LOCKLEAR, LOCKLEAR & JACOBS, PLLC

August 13, 2023

**RE: Harnett HS Press Box Replacement
(Header and Corner Structural Review)**

SHEET TITLE:  
**EXTERIOR ELEVATIONS**  
SHEET NUMBER:  
**G-201**  
PROJECT# 21-1110

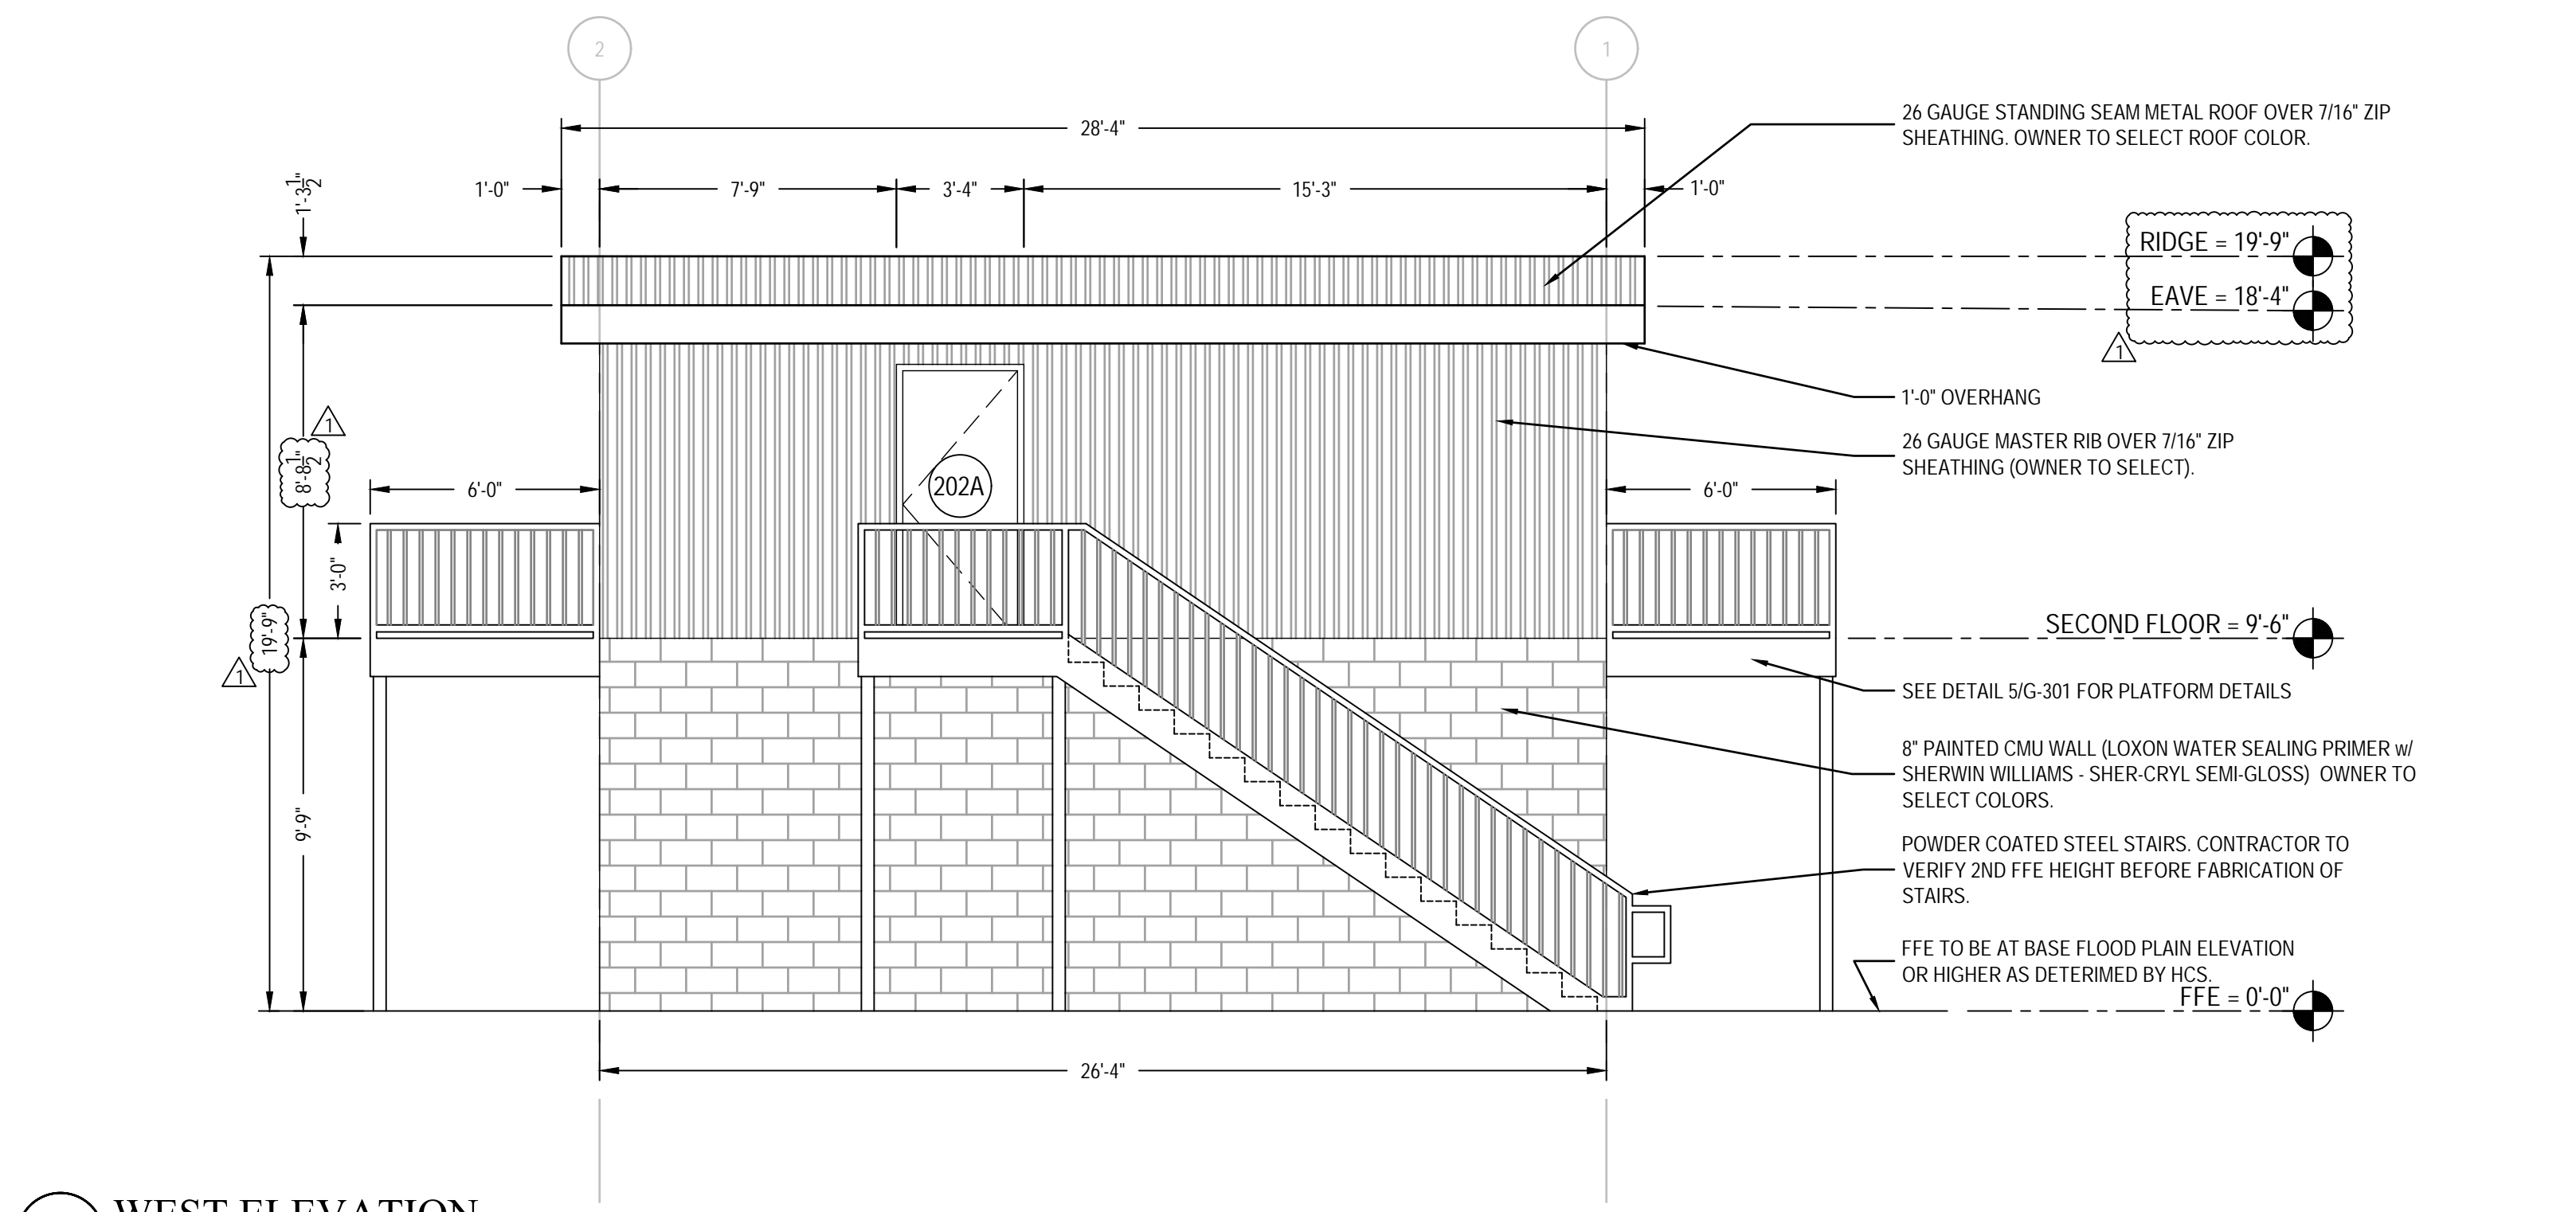
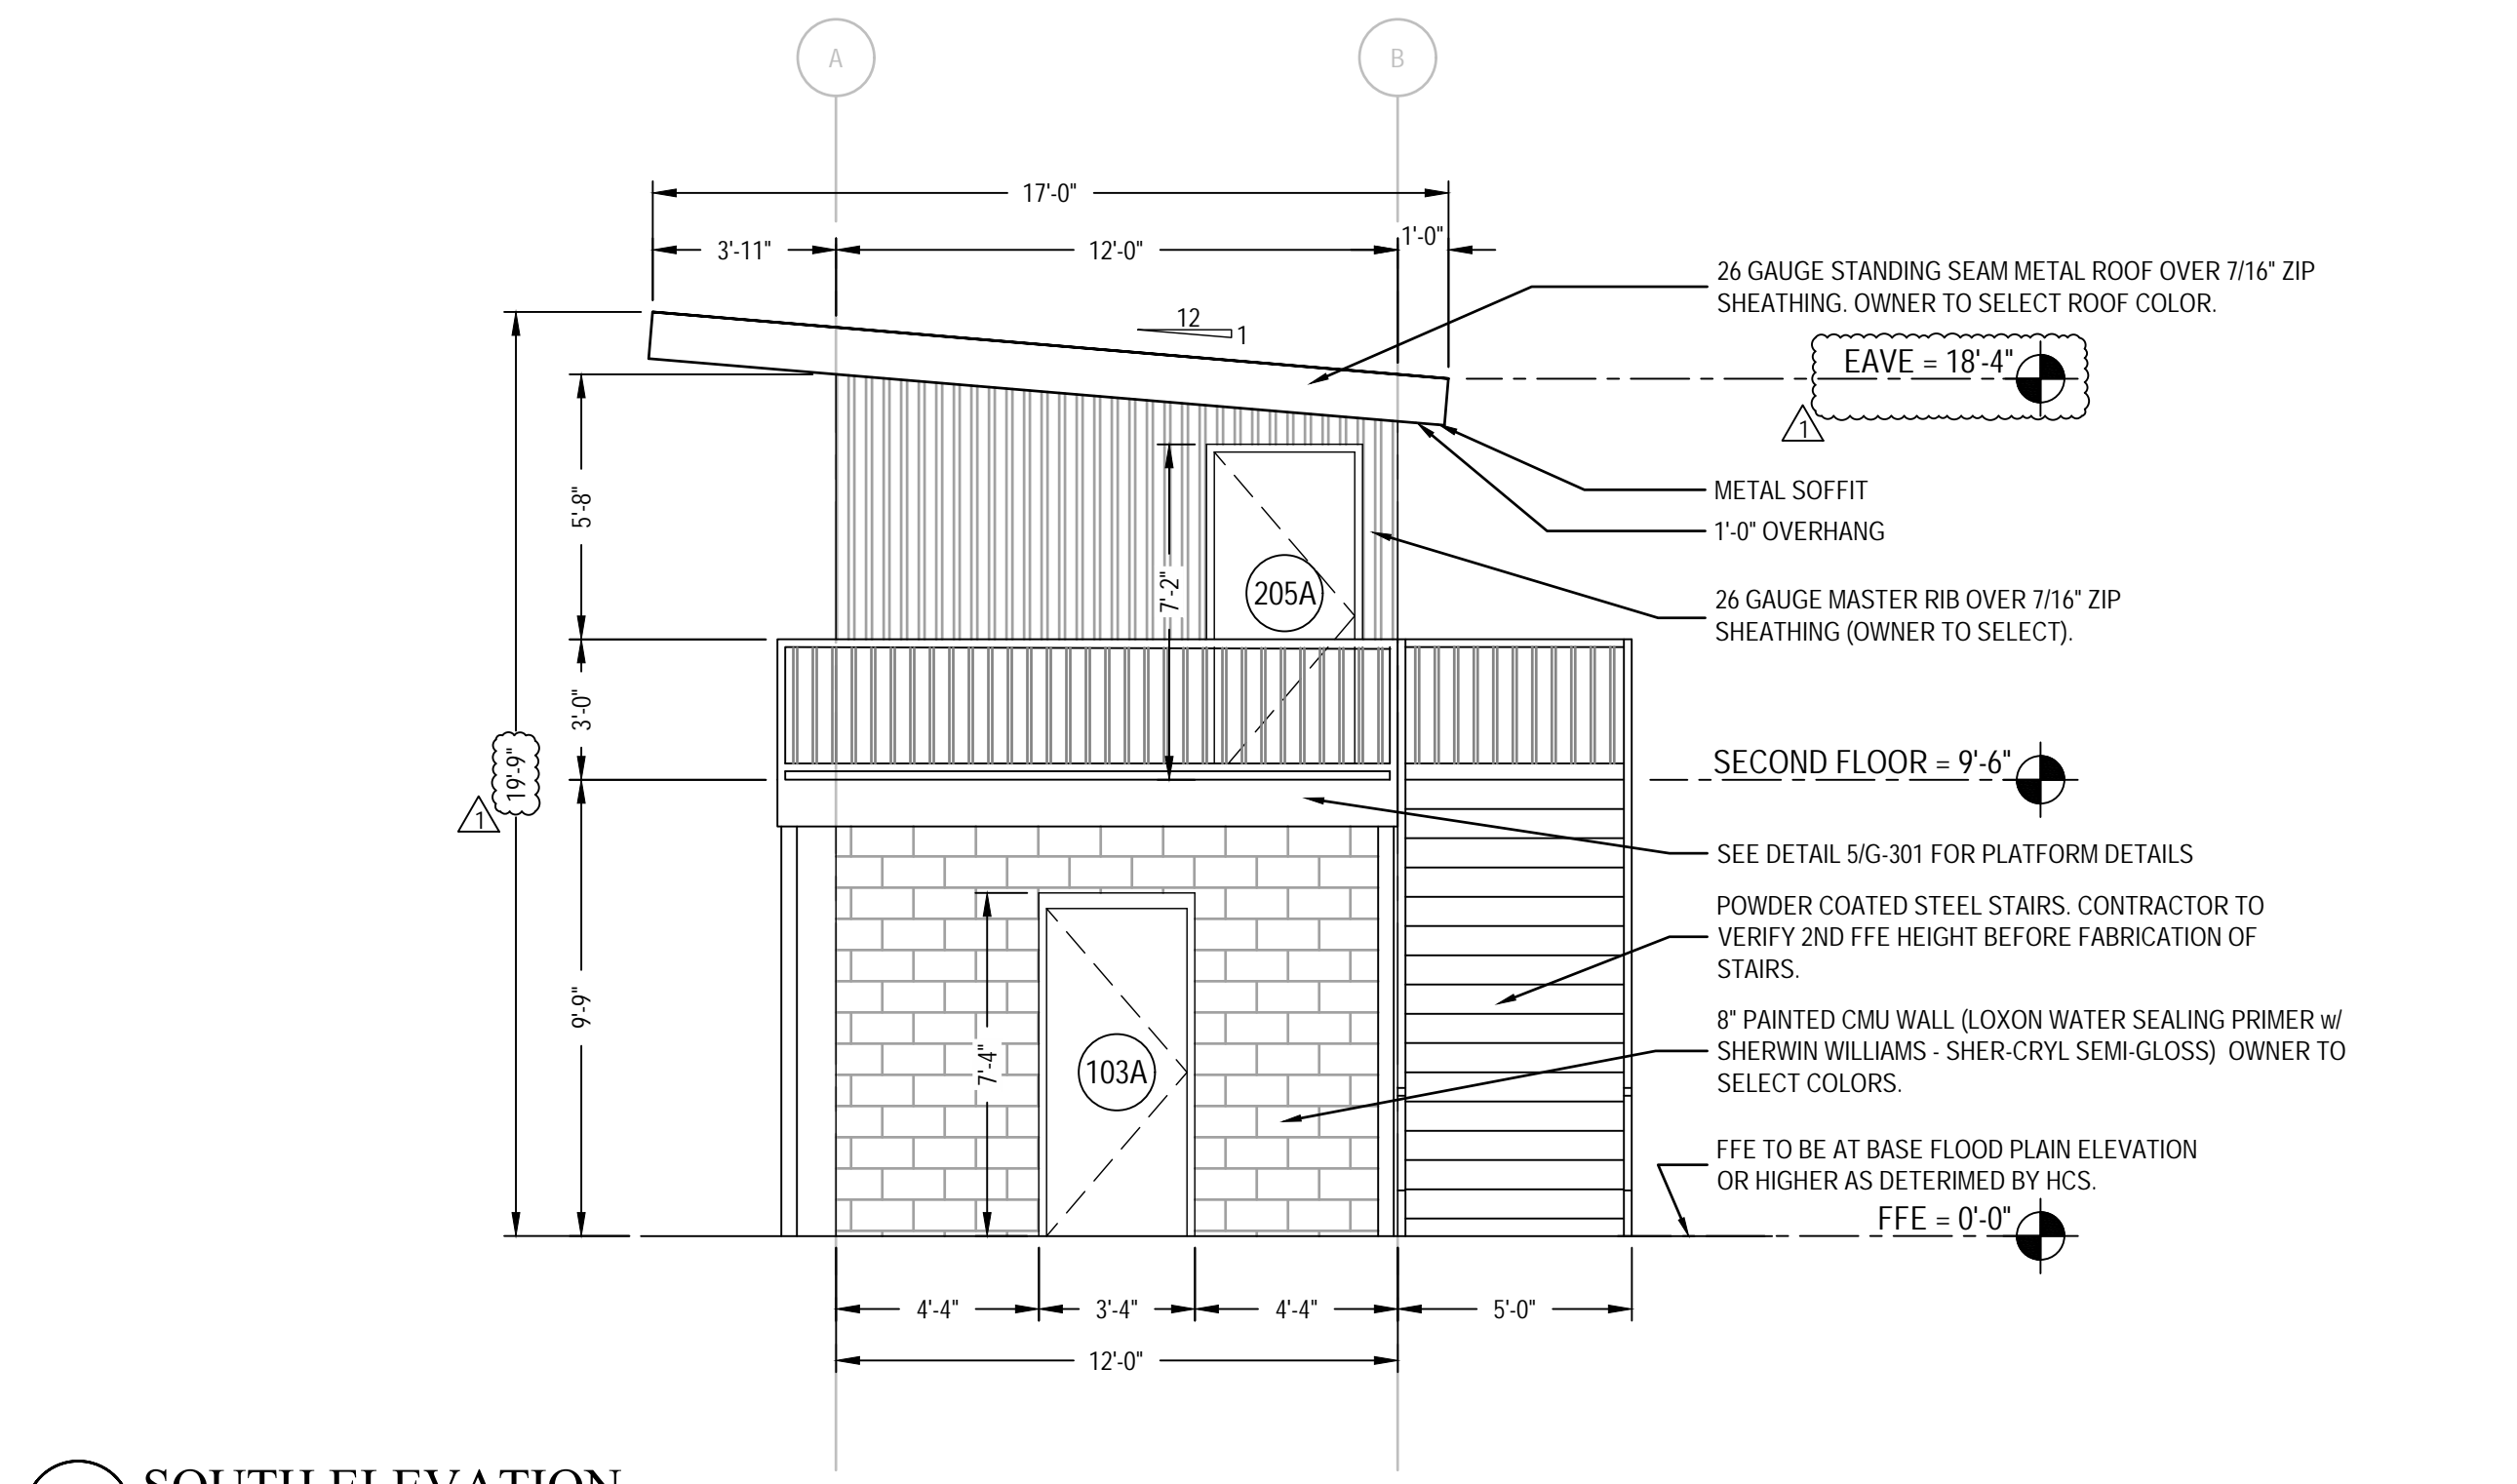
- The exterior door headers on the 2nd floor of both did not match the plans due to height restrictions and
- The corner studs we rearranged from the typical 3 stud fashion and was changed to a “U” shape layout.

- Exterior Door Headers – A review of the door header on the Western Wall at Harnett Central and the Eastern Wall on Westen Harnett was performed to check the current header as is. Both headers are sufficient. The other exterior doors on the endwalls of the building are framed in solid and have minimum load on them. They are sufficient as well.
- The contractor was advised to block in the corner studs at a minimum of 3rd points and attached these members so they for a typical corner stud situation. This should correct the framing modifications and the corners studs should be sufficient as well.
